# Rezoning Transportation Analysis

Petition Number: 2022-131

**From:** Jake Carpenter, PE  
Jacob.carpenter@charlottenc.gov  
980-221-5675

Revision Log:	Date	Description
	12-29-22	First Review (PDM)

RZ-2

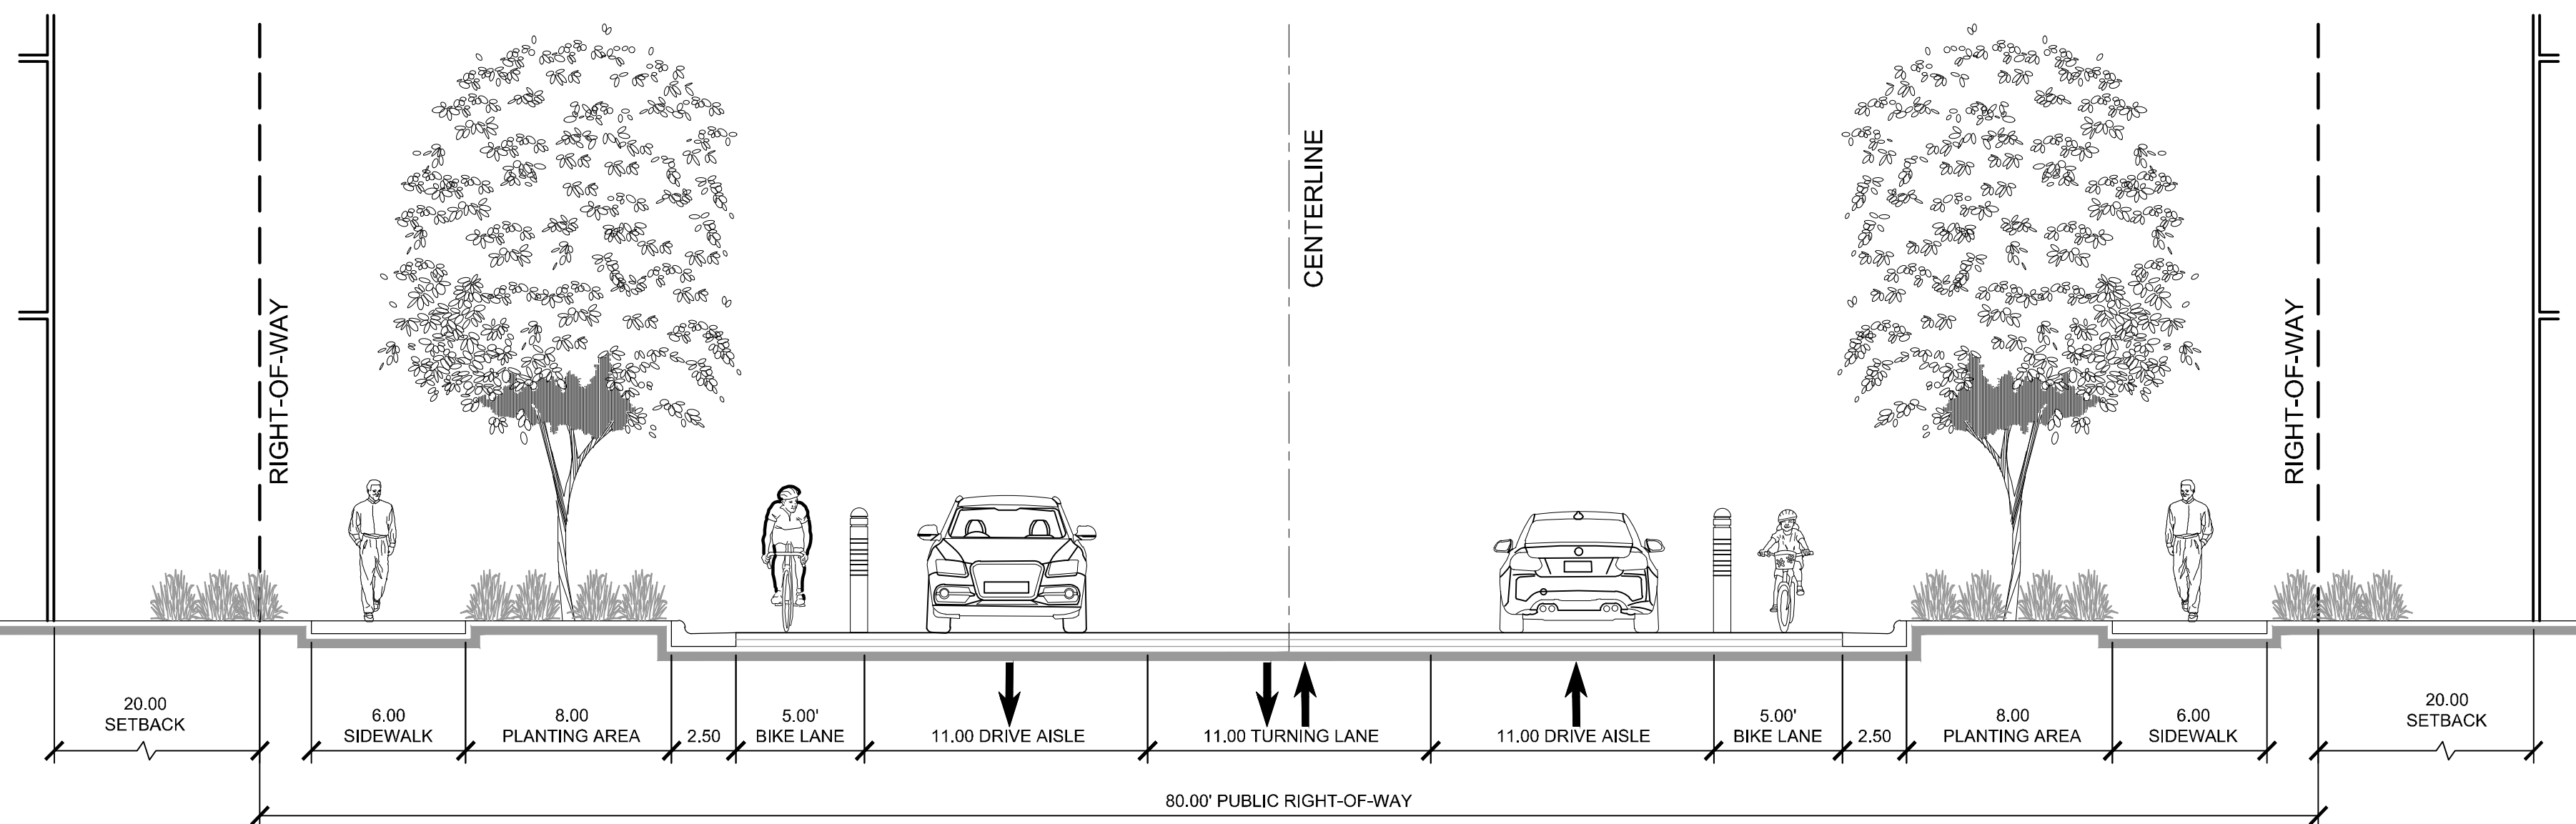
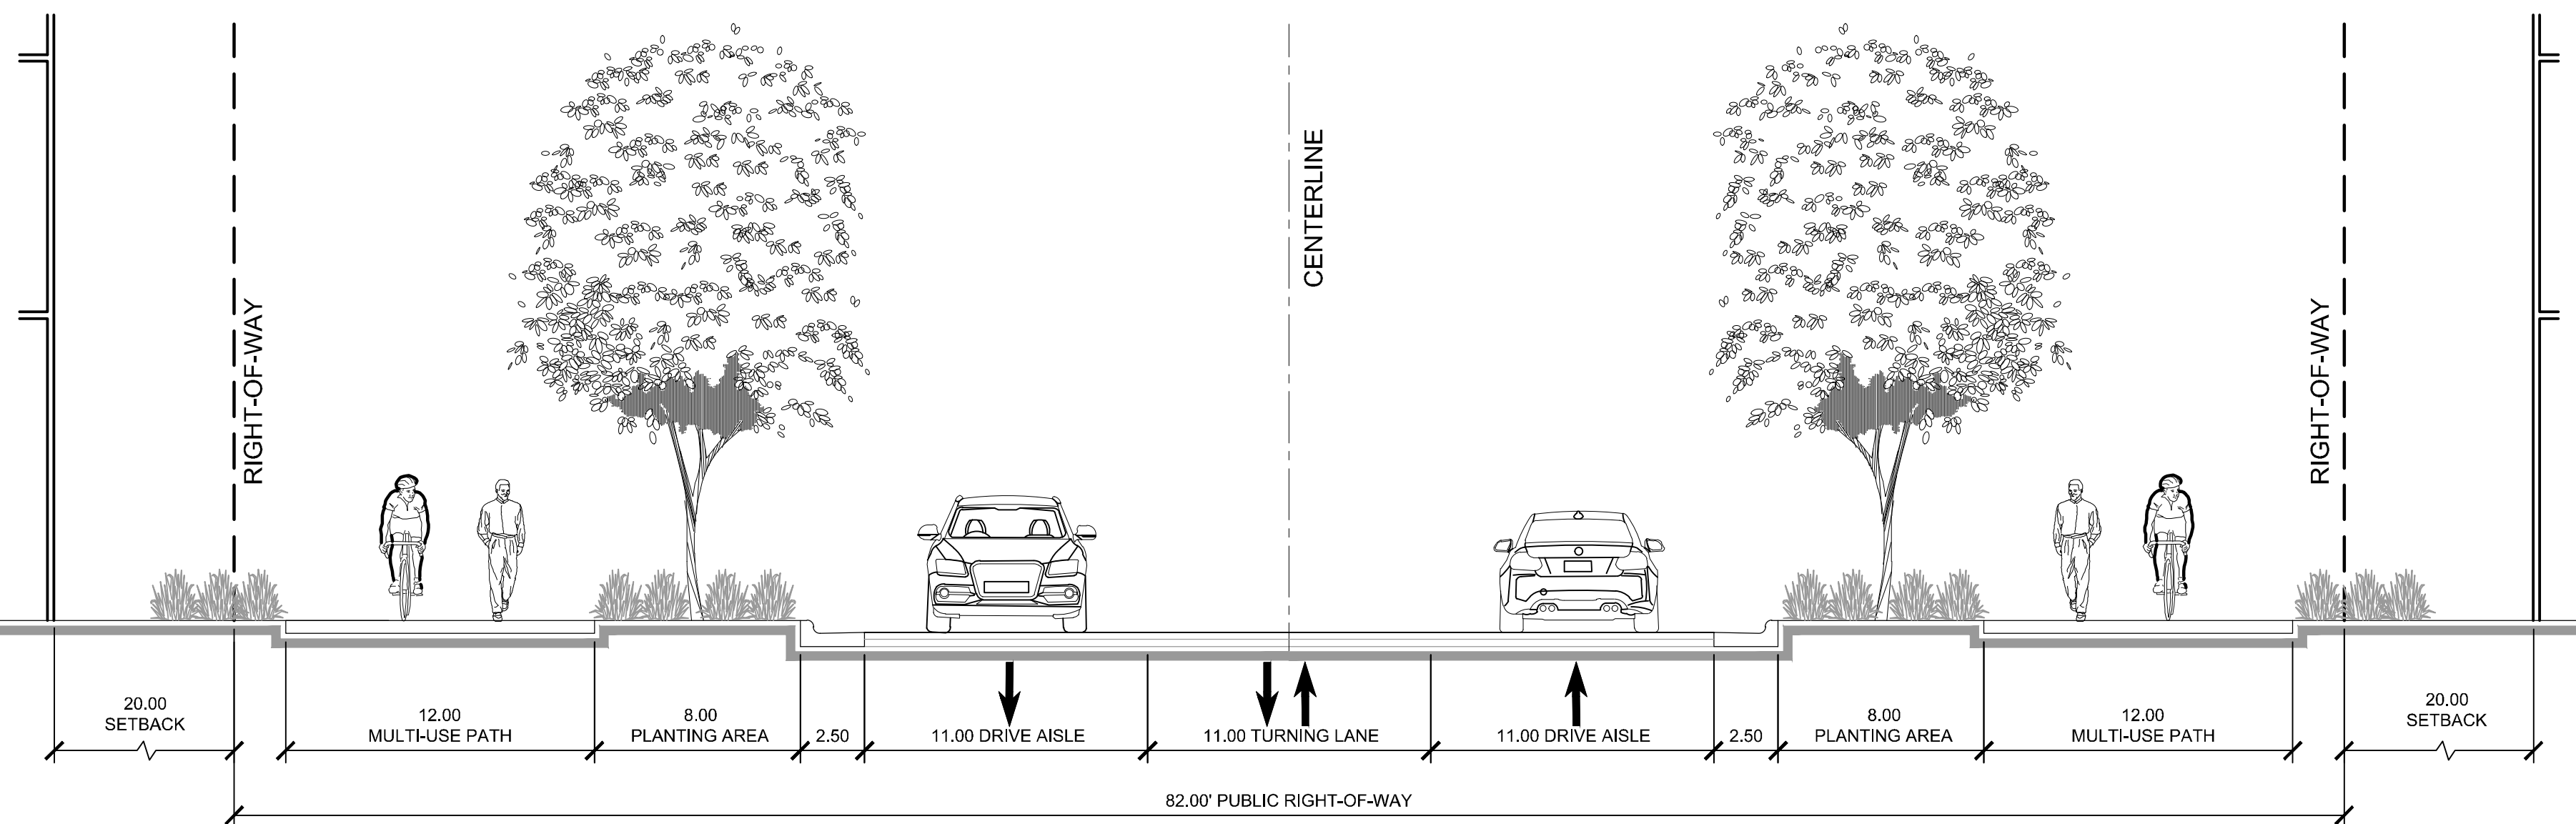
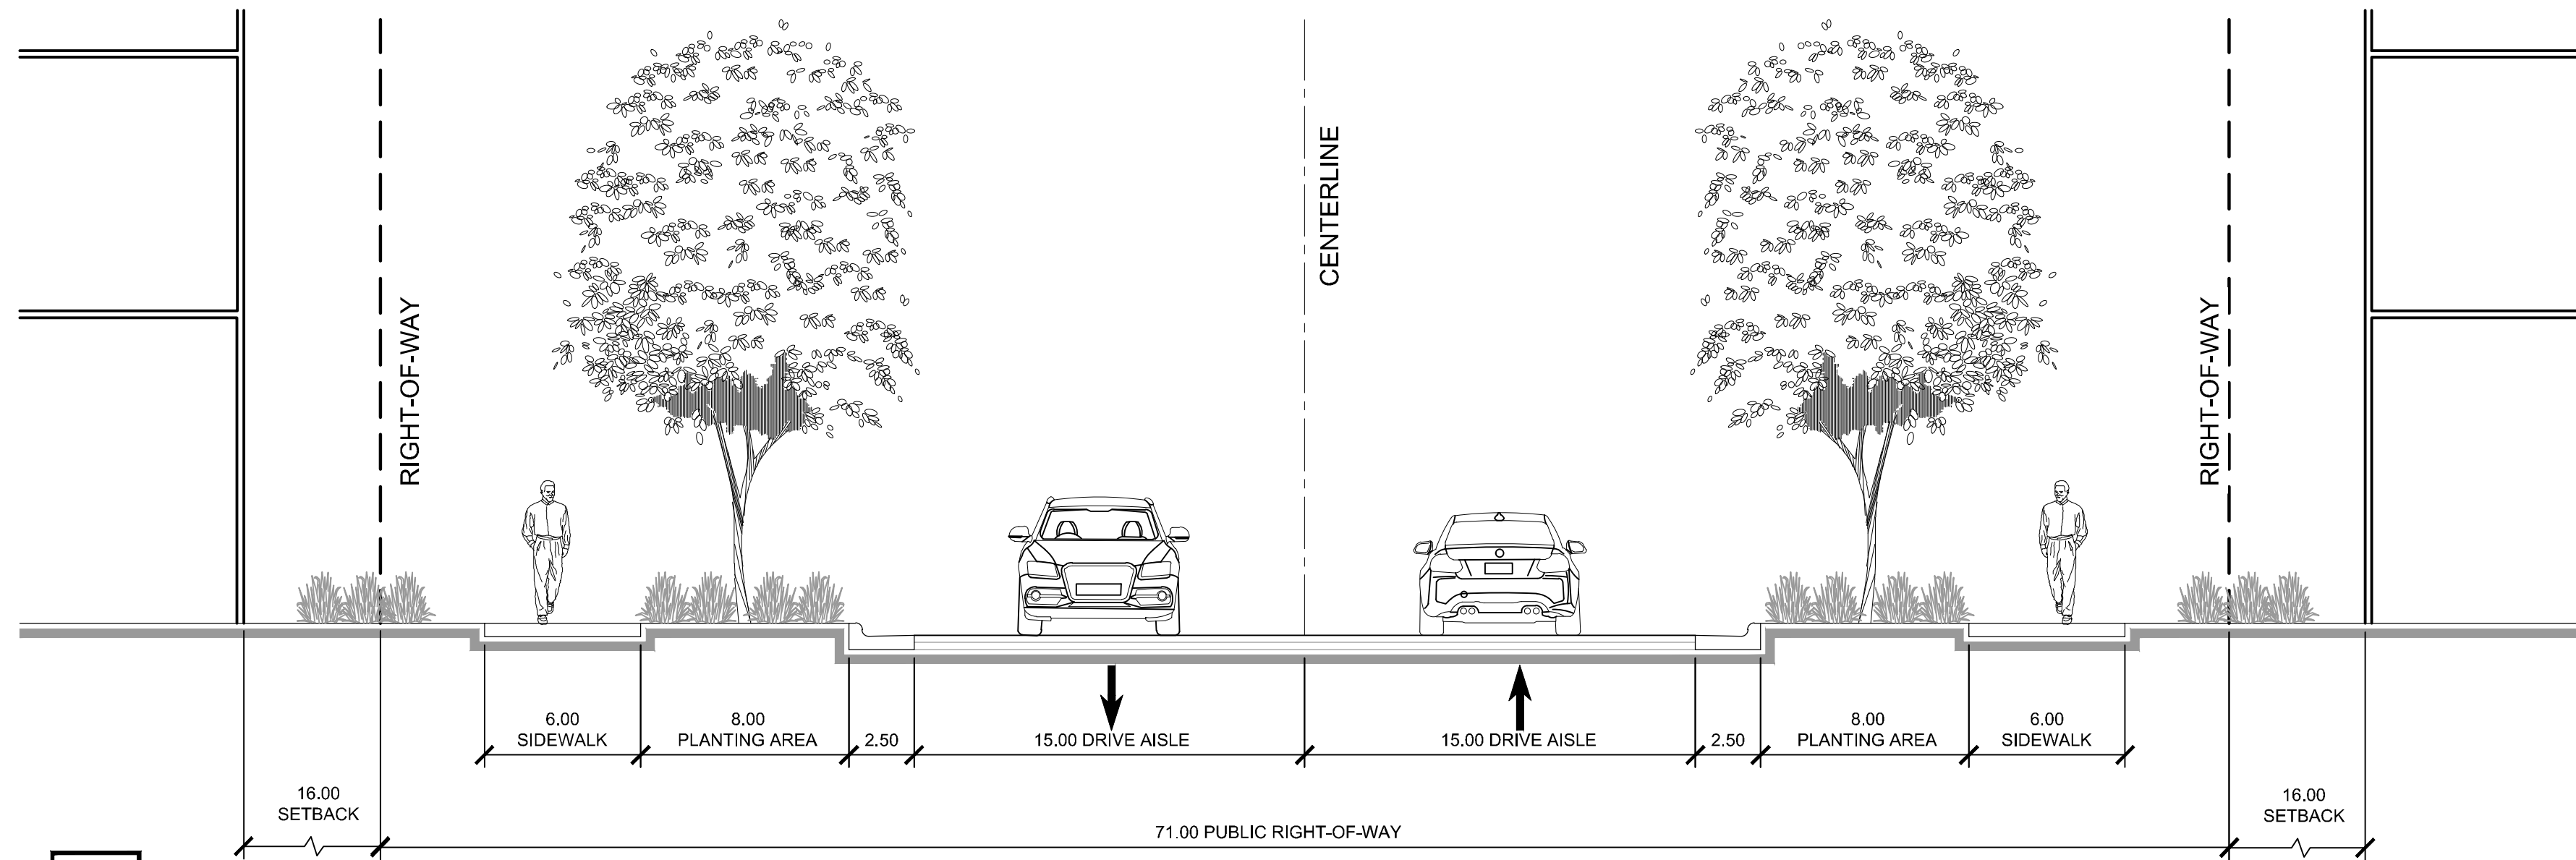
- Revise site plan to provide a north arrow and scale.
- Add a conditional note specifying "All transportation improvements will be approved and constructed before the site's first building certificate of occupancy is issued. The petitioner may phase transportation improvements if said improvements and phasing are explicitly described in site plan notes."

- Add conditional note specifying "All public roadway improvements will be subject to the standards and criteria of CDOT and NCDOT, as applicable, to the roadway improvements within their respective road system authority. It is understood that such improvements may be undertaken by the Petitioner on its own or in conjunction with other development or roadway projects taking place within the broad western Mecklenburg area, by way of a private/public partnership effort or other public sector project support."
